From: Jeremiah Cromie <jeremiah.cromie@co.kittitas.wa.us>
Sent: Monday, July 26, 2021 3:49 PM
To: Candie Leader <candie.leader@co.kittitas.wa.us>; Melissa Schumaier <melissa.schumaier@co.kittitas.wa.us>; Holly Erdman <Holly.erdman@co.kittitas.wa.us>; Jesse Cox <jesse.cox@co.kittitas.wa.us>; tyro461@ecy.wa.gov; gcle461@ecy.wa.gov; lowh461@ECY.WA.GOV; Rich Elliott <elliotttr@kvfr.org>; Pat Nicholson <pat.nicholson@co.kittitas.wa.us>; rusj461@wcy.wa.gov; trevor.hutton@ecy.wa.gov
Cc: Jeremy Johnston <jeremy.johnston@co.kittitas.wa.us>
Subject: LP-08-00024 Wildcat Plat Follow-up comments?

I have reviewed the Application for the Wildcat (LP-08-24) and Tiger (LP-08-22) Plats. I provide review of proposed development and construction for Kittitas County Fire District 2. The Fire District has no code enforcement authority so my input is, for the most part, informational only.

From: [Pat Nicholson](#)
To: [Jeremiah Cromie](#)
Subject: RE: LP-08-00024 Wildcat Plat Follow-up comments?
Date: Tuesday, July 27, 2021 8:03:52 AM

WILDCAT PLAT
PORTION OF SECTION 32, T. 18N., R. 19E., W.M.
KITITAS COUNTY, STATE OF WASHINGTON

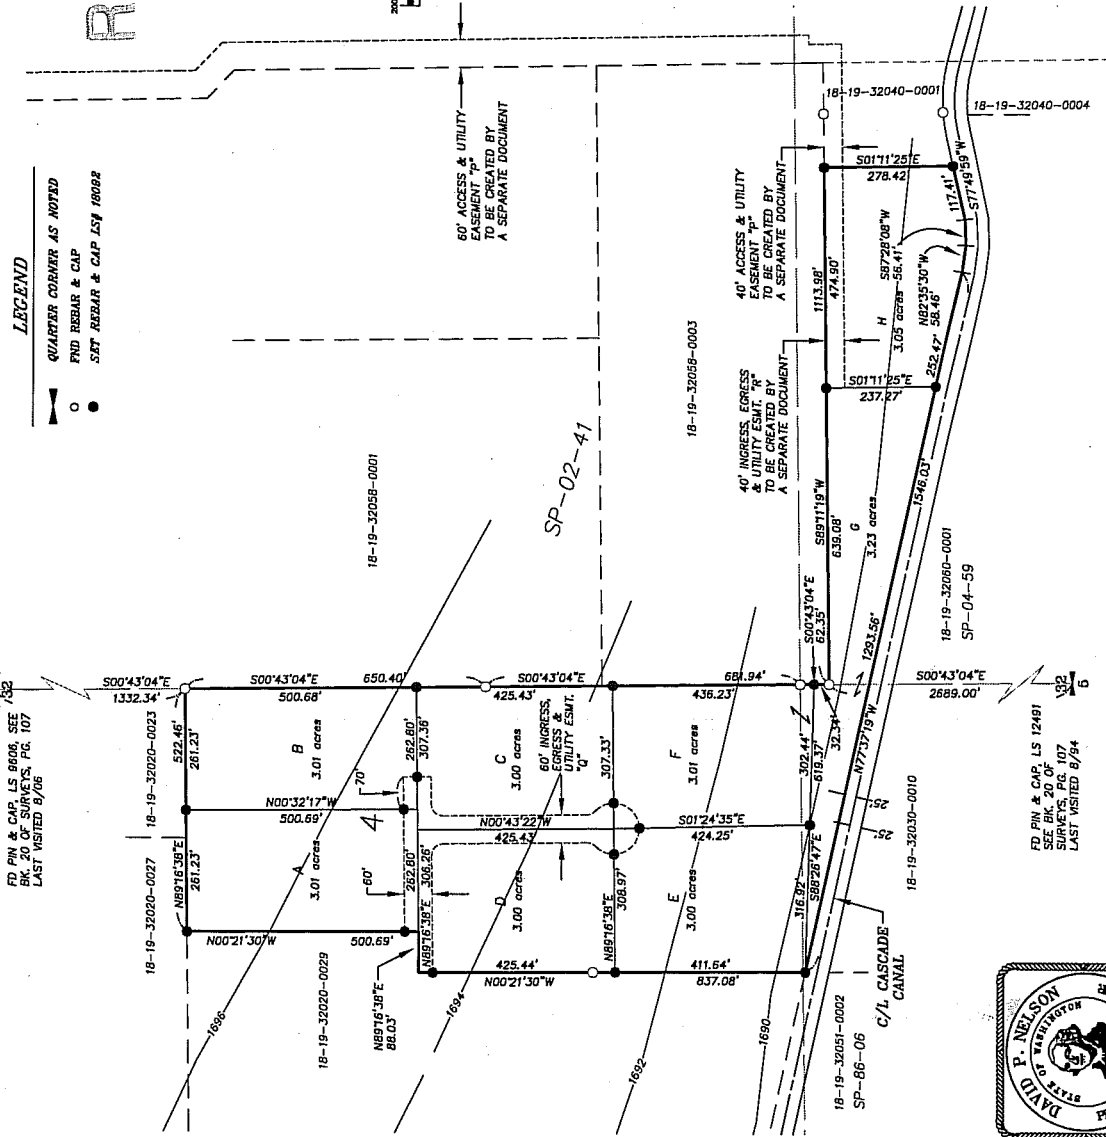
1. The addresses need to be clearly visible from both directions at the county road for all properties.
2. The fire department access road needs to be capable of supporting 75,000lbs in all weather, be 20' wide, provide 13'6" vertical clearance and provide for adequate turn-around for fire department apparatus in accordance with IFC 2006 – Appendix D. All cul-de-sacs need to be compliant.

3. Water supply should be addressed in compliance with the International Wildland-Urban Interface Code. It appears that development is proceeding in stages. Each stage in and of itself is fairly small and fire code requirements would be minimal. However, looking at this from a broader perspective, these projects cumulatively extend quite a ways from Wilson Creek Road with possible plans to extend beyond the current proposal(s). This can pose a significant challenge for water supply for fire suppression efforts and should be addressed collectively.

4. Depending on the eventual scope of this project, a second ingress/egress road may be required by the IFC.

There was no information provided by the applicant addressing fire-flow requirements for this development. This is a rural development with no fire hydrants in the area to provide required fire-flow.

Section 404 of the Wildland Urban Interface Code provides information about water supplies. If the development is anticipated to have residential dwellings 3,600 SF and smaller, minimum water requirements for manual fire suppression would be 1,000 gallons per minute delivered at 20 PSI for 30 minutes, or 30,000 gallons. If all of the homes are equipped with fire sprinklers, this volume can be reduced by 50% to 15,000 gallons. Conforming fire hydrants are required every 500 feet. If any of the structures exceed 3,500 SF, the water requirements would increase to 1,500 gallons per minute for 30 minutes.

The required fire-flow water would need to be available at the development through a fire hydrant system. Private fire hydrants and fire-flow water tanks require a Fire Marshal Permit. I am no longer approving retention ponds for fire-flow. If there is documented previous approval, I would consider a retention pond for the fire water storage. It is likely that a fire pump would be required to achieve the volume and pressure needed to supply the fire hydrants from a water storage tank.

Utilizing the WUIC method for this project as suggested by Kittitas Valley Fire Rescue in 2008 is a reasonable and acceptable method to determine fire-flow requirements for this older approval.

Consistent with Kittitas Valley Fire and Rescue's 2008 comments, the fire hydrant system can be established in phases with the development and be extended with subsequent phases.
